Pilar Aberasturi - Re: MP 11_0009 MOD 1 - Miranda Dentist Hospital.

Council raised a number of issues about the intensity of the development when the original application was being assessed. These primarily related to the large amount of floor space proposed, the relatively small number of parking spaces proposed and some aspects of the building itself.

As the proposed modification essentially involves 12% more floor space and no additional parking, it follows that Council's concerns in relation to the impact that the intensity of the development will have on the locality (traffic, parking, etc.) remain and are amplified.

EAST & NORTH ELEVATIONS

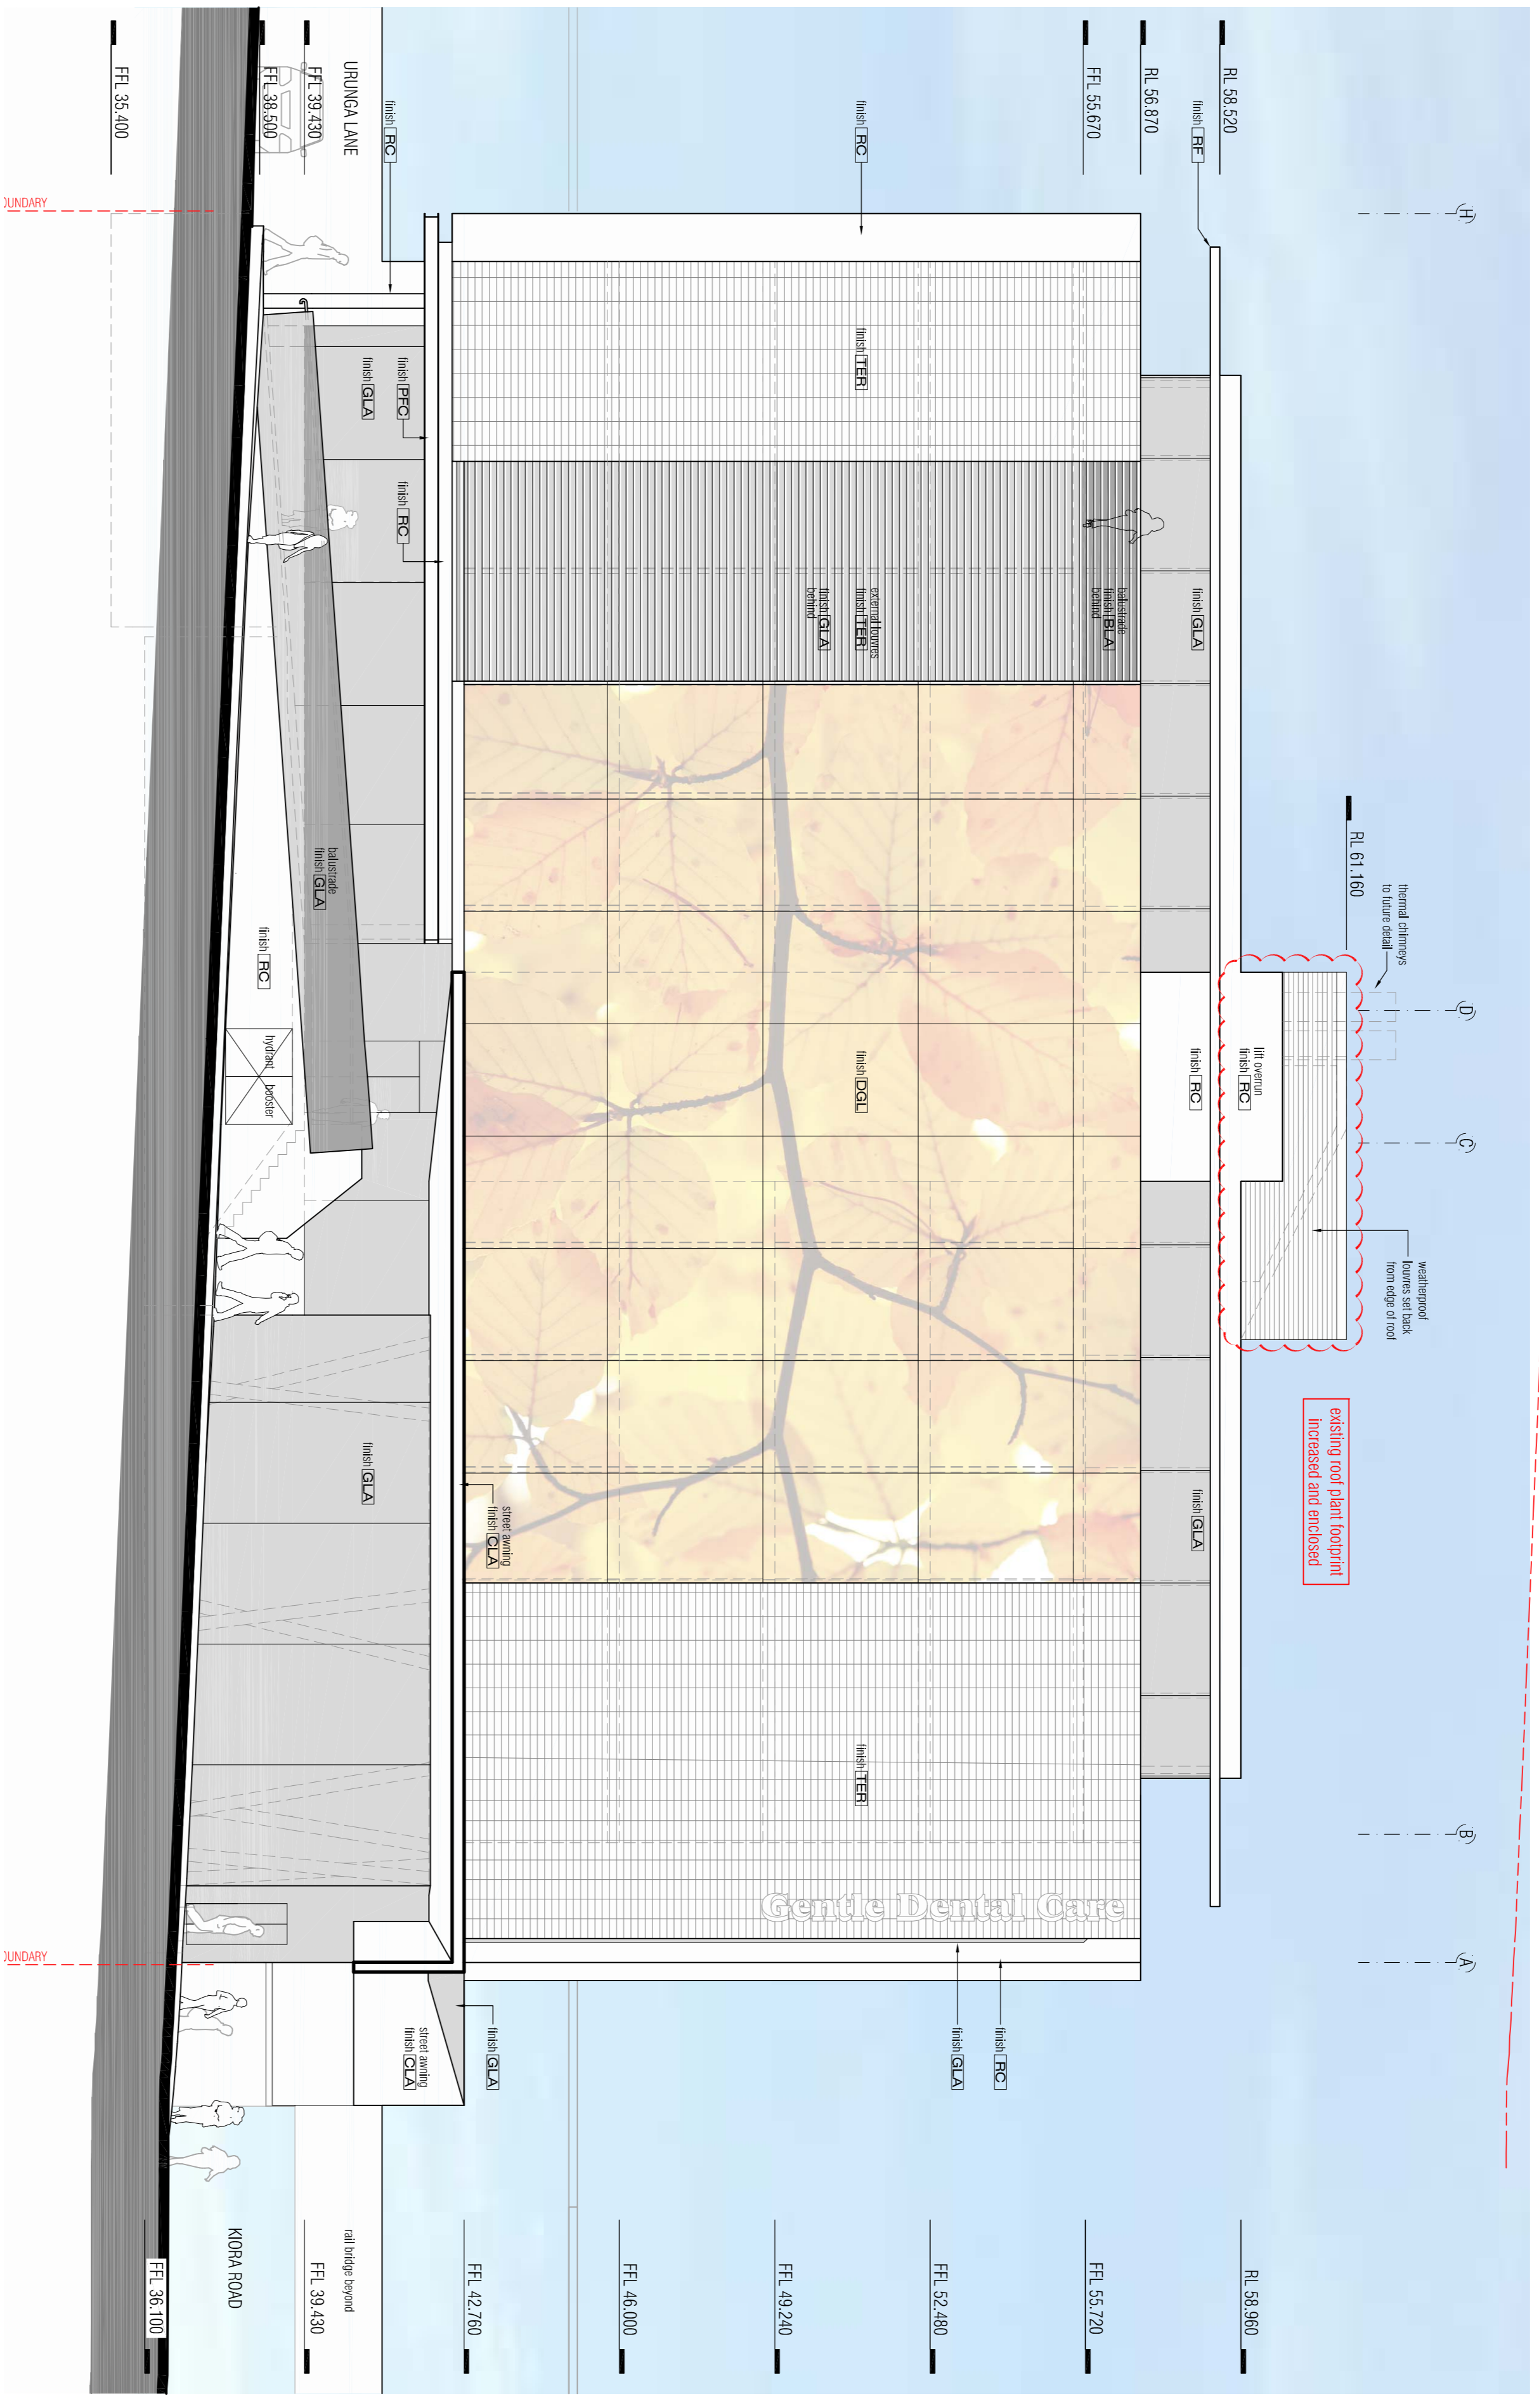
Roof top plant - The information provided states that the plant will be setback and screened, however, no plans were provided. The roof top will be visible from the vantage points in tall buildings nearby and care needs to be taken to

ensure that it is not unattractive.

**Figure 5: basement floor plan showing bicycle rack storage for 5 bicycles**

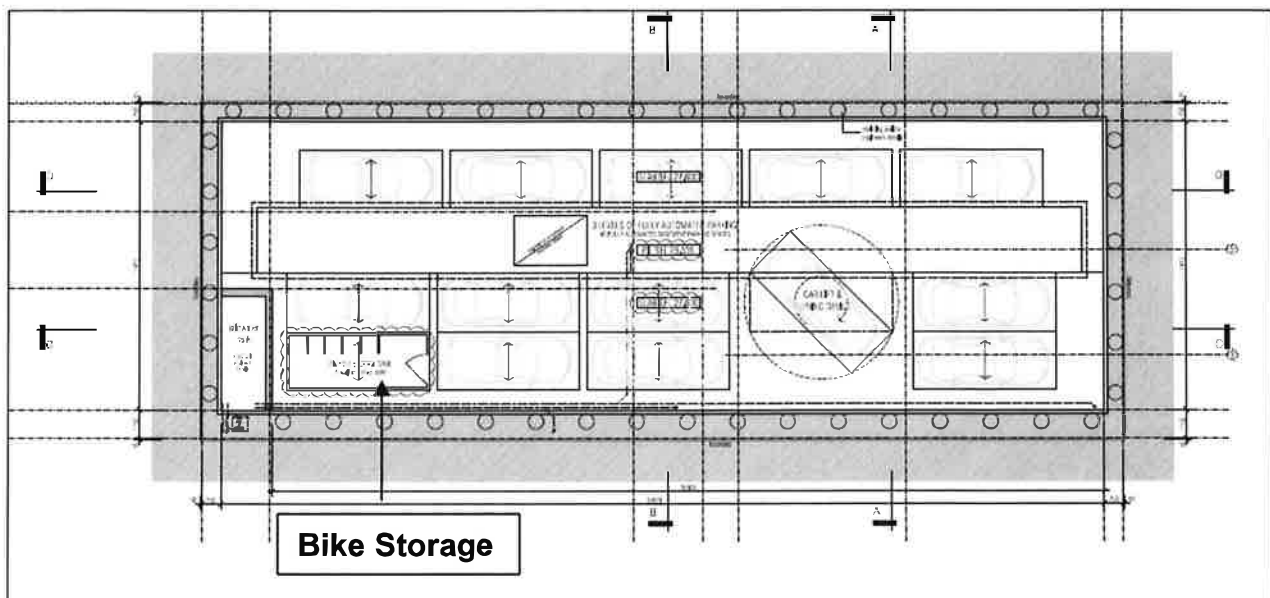
Bicycle parking - Without plans, the proposed changes are difficult to assess. Council would only be concerned that bicycle parking provided is safe and practical so that it is used.
